Application by Highways England for the A47 Blofield to North Burlingham project
The Examining Authority's written questions and requests for information (ExQ2)
Issued on 28 September 2021.

ExQ2: 28 September 2021**Responses due by Deadline 5: Tuesday 19 October 2021**

**SECTION B-B**  
**SCALE 1:50**

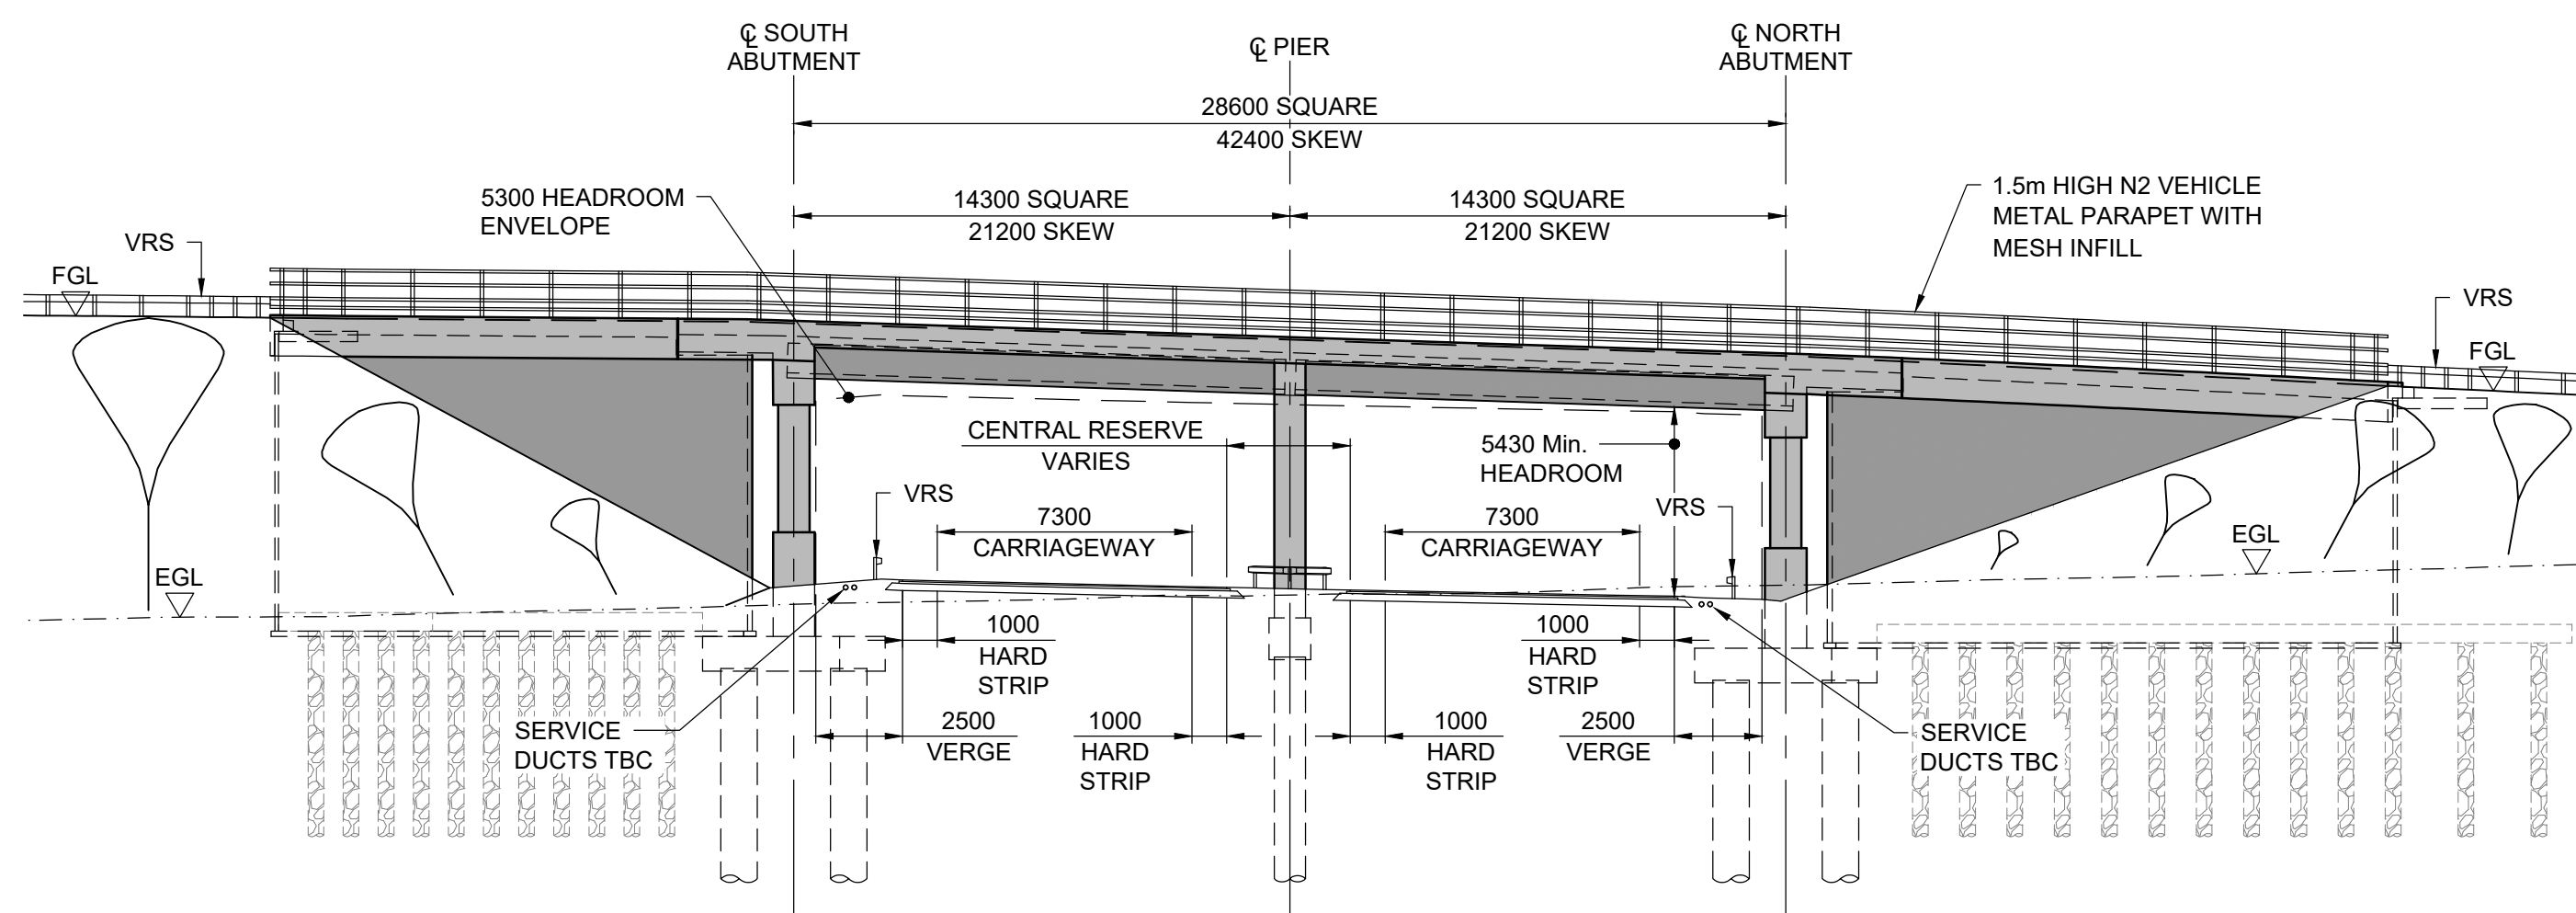
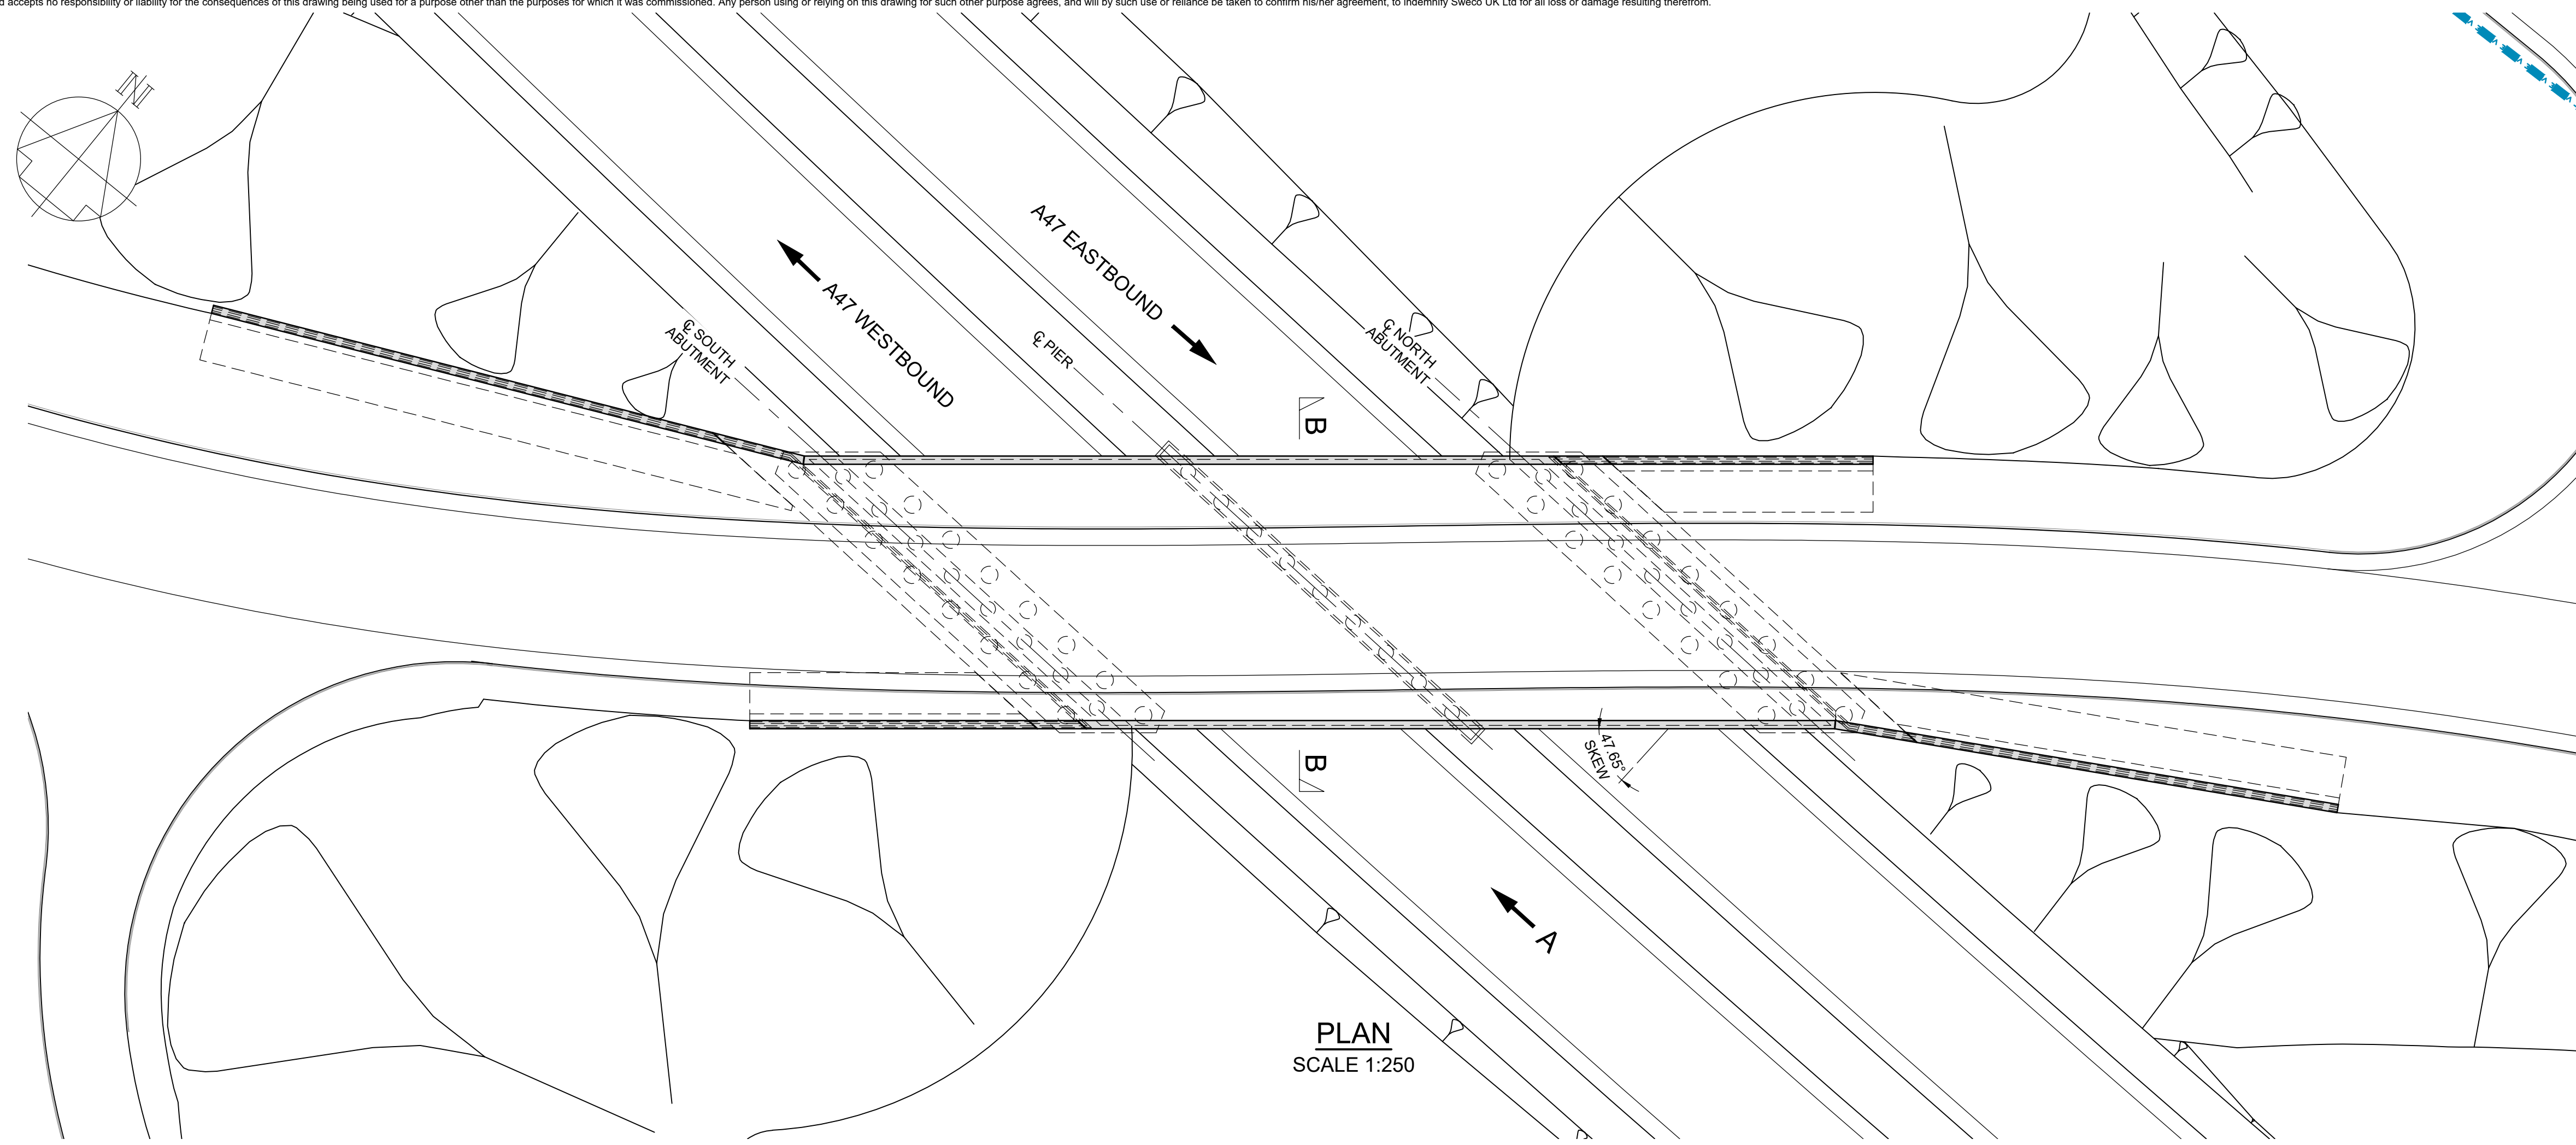
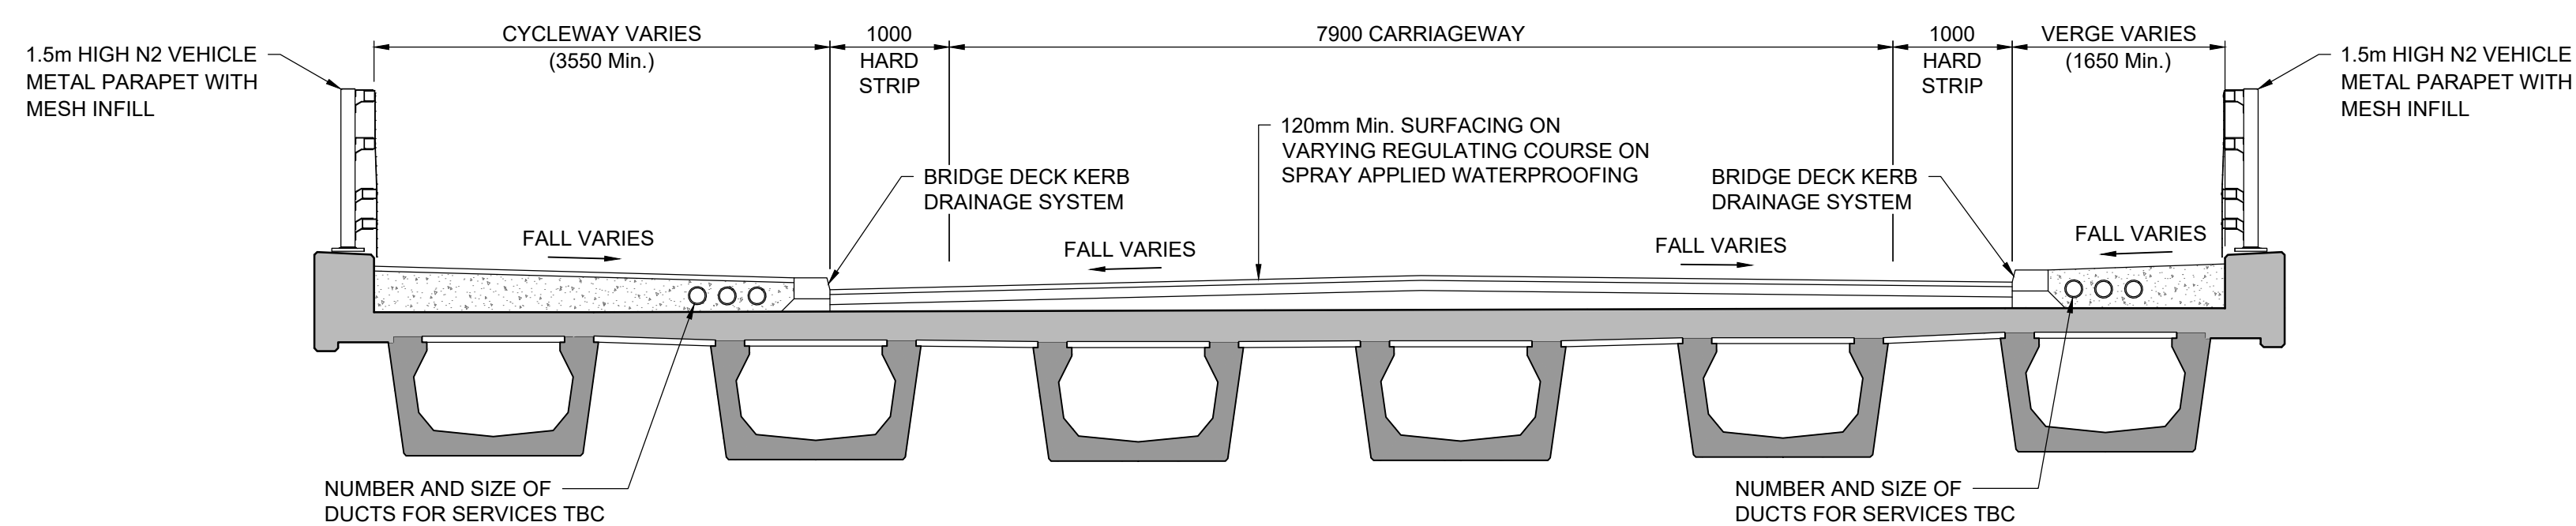
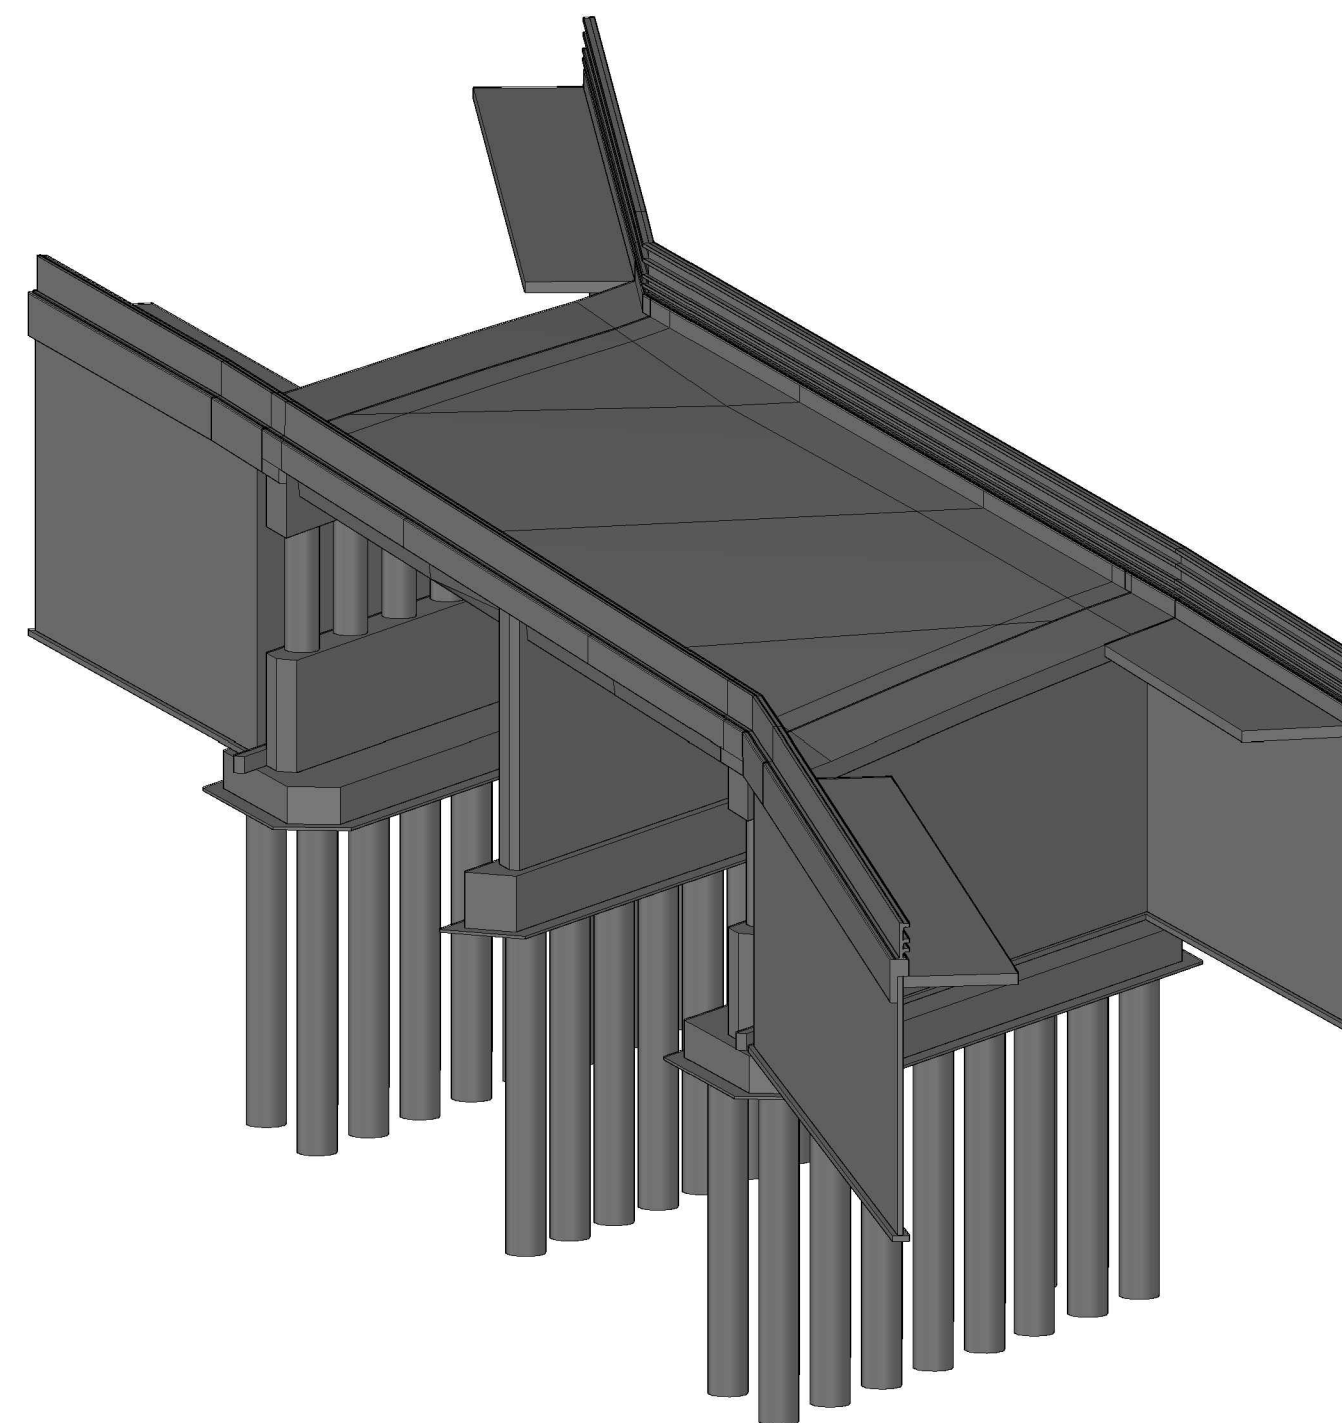
2.14.3	The Applicant	Please: a) explain how shared cycle tracks would be separated from carriageways; and b) clarify whether the separation on overbridges would be provided by the 1000mm width area identified as 'Hard Strip' between the carriageway and the cycleway on the section drawings within the Engineering Drawings and Sections [REP4-005]?
